Ribble Valley Borough Council
Housing & Development Control

Your ref: 3/2022/0965
Our ref: D3.2022.0965
Date: 17th April 2023

Application no: **3/2022/0965**

Address: **Betty Barn Slaidburn Road Waddington BB7 3JQ**

Rev	Date	Drawn by	Comments	Scale
Client				
Project				
Betty Barn				
Slaidburn Road				
Waddington				
Drawing				
Proposed Site Plan				
Date	29.09.2022	Drawn by	HA	Scales
				1:200 @ A1
Job No - Dwg No - Rev				
22065 - SP - A

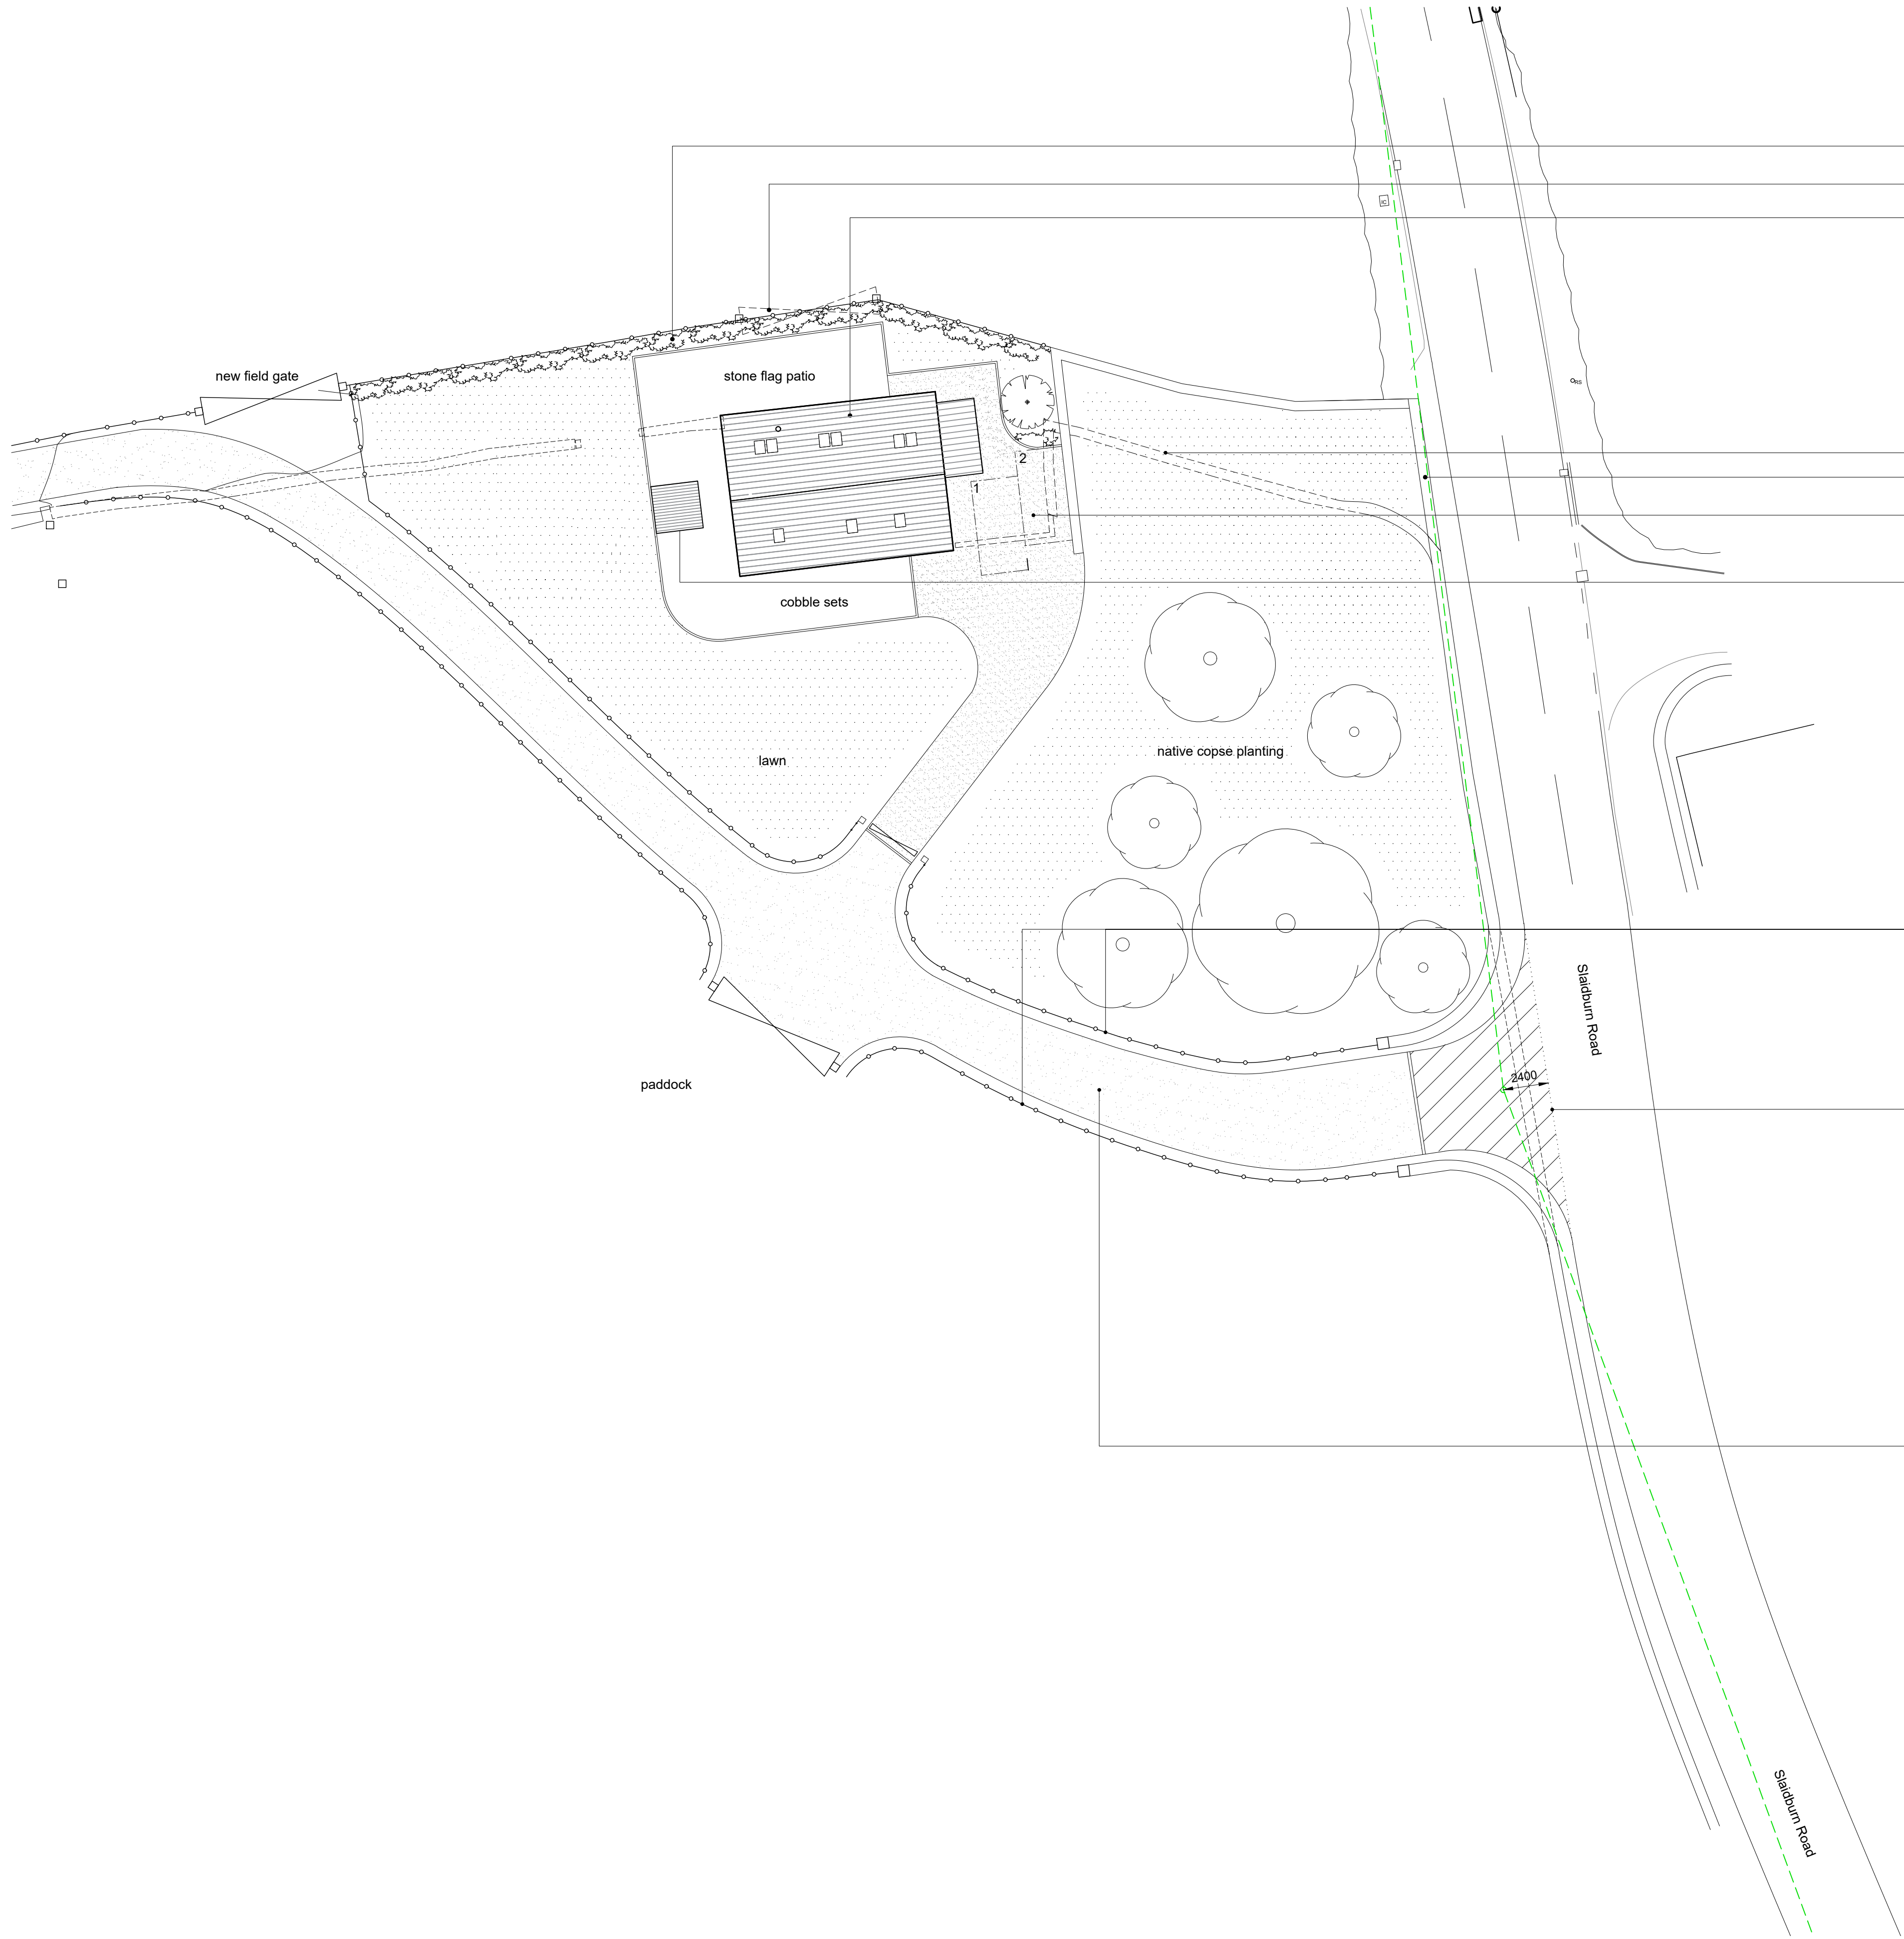
The LHA have reviewed drawing number 22065-SP titled "Proposed Site Plan" and are aware that the relocated shared access has already been approved under application reference 3/2019/1036 and the new access has already been formed. Therefore, given that the relocation has already been approved, the LHA have no objection to this.

The LHA will however condition, alike the previous application, vehicular visibility splays of 2.4m x 70m to the north and 100m to the south are provided at the site access.

The LHA have reviewed drawing number 22065-SP titled "Proposed Site Plan" and are aware that 2 car parking spaces will be provided for the 3-bed dwelling which complies with the parking standards as defined in the Joint Lancashire Structure Plan. Therefore, the LHA have no objection to the proposal.

The LHA are also aware that an access which serves a field will be relocated internally as part of the works. Given that the access is located internally and does not serve any Public Rights of Way, the LHA have no comments to make regarding the relocation.

1. No part of the development hereby permitted shall be occupied until such time as the access arrangements shown on drawing number 22065-SP titled "Proposed Site Plan" have been implemented in full.

3. No part of the development hereby permitted shall be occupied until such time as vehicular visibility splays of 2.4 metres by 70 metres to the north and 2.4 metres by 100 metres to the south have been provided at the site access. These shall thereafter be permanently maintained with nothing within those splays higher than 1 metres above the level of the adjacent footway/verge/highway.

5. The development hereby permitted shall not be occupied until such time as the parking and turning facilities have been implemented in accordance with drawing number 22065-SP titled "Proposed Site Plan". Thereafter the onsite parking provision shall be so maintained in perpetuity.
